## Appeal Decision

**Appeal Ref: APP/R5510/D/24/3346390**

**13 Chestnut Close, Hayes UB3 1JF**

- The appeal is made under section 78 of the Town and Country Planning Act 1990 (as amended) against a refusal to grant planning permission.
- The appeal is made by Mrs Kellie Portugal Walker against the decision of the Council of the London Borough of Hillingdon.
- The application Ref is 78553/APP/2024/283.
- The development proposed is erection of single storey rear extension following demolition of extension.

DWG NO:	ISSUE
TRICON/13CC/104	A

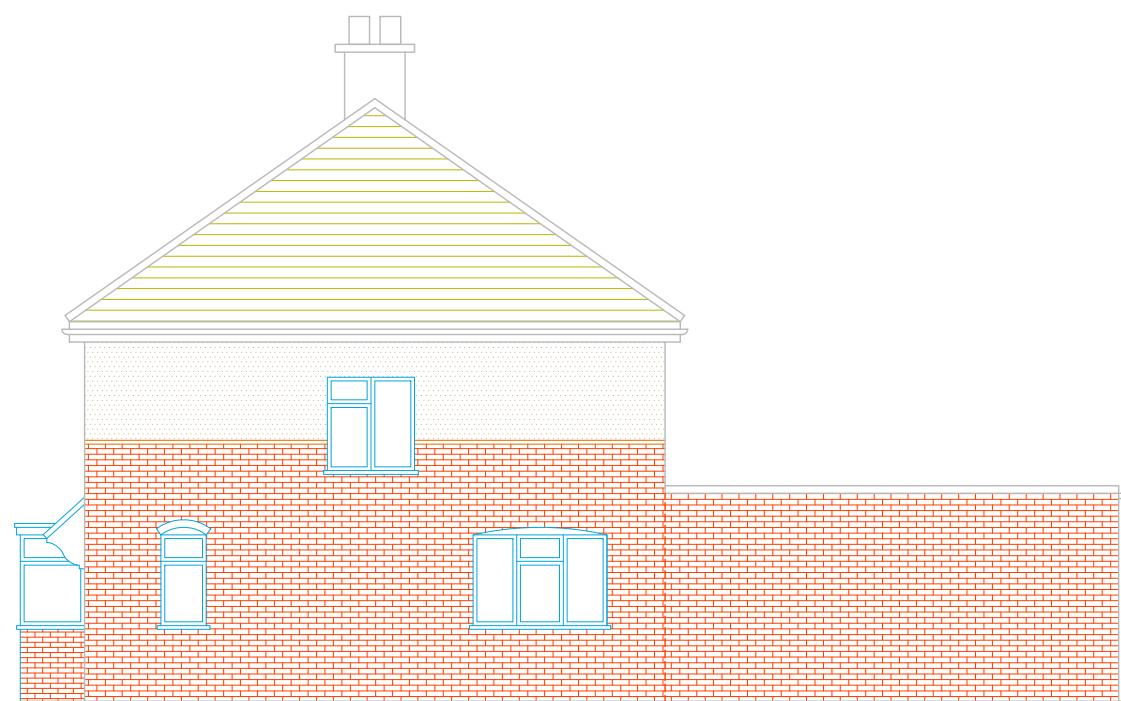
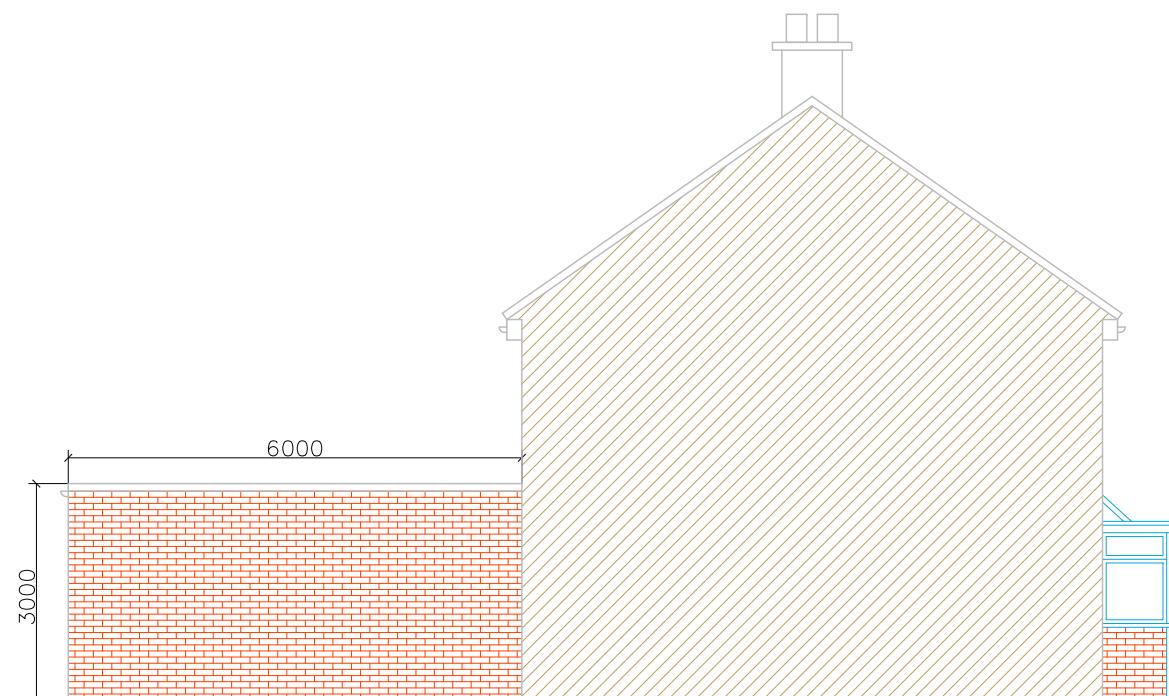
3. Notwithstanding that an existing outside toilet and garden structure would be removed, the proposed 6m deep extension would significantly increase the footprint of the appeal property. It would extend further into the garden than the two neighbouring extensions which the Council indicates are broadly in line with the 3.6m depth permitted by Policy DMHD 1. There are no other, deeper extensions in the visual context of the appeal site. In my judgment the proposed extension would appear incongruous and overly dominant to the host property and would out of character with similar development in the surrounding area.

6. I conclude that the depth and resulting bulk of the proposed extension would appear as a disproportionate and incongruous addition that would fail to respect the design and size of the original dwelling. The extension would harm the character and appearance of the host property. Due to its size, it would also fail to respect the prevailing character and appearance of the surrounding area. The proposal is therefore contrary to the design policies of Policy BE1 of the Hillingdon Local Plan: Part One - Strategic Policies (November 2012) and Policies DMHB 11, DMHB 12 and DMHD 1 of the Hillingdon Local Plan: Part Two - Development Management Policies (January 2020). There would also be conflict with the design aspirations of Policy D3 of the London Plan (2021) and the National Planning Policy Framework.
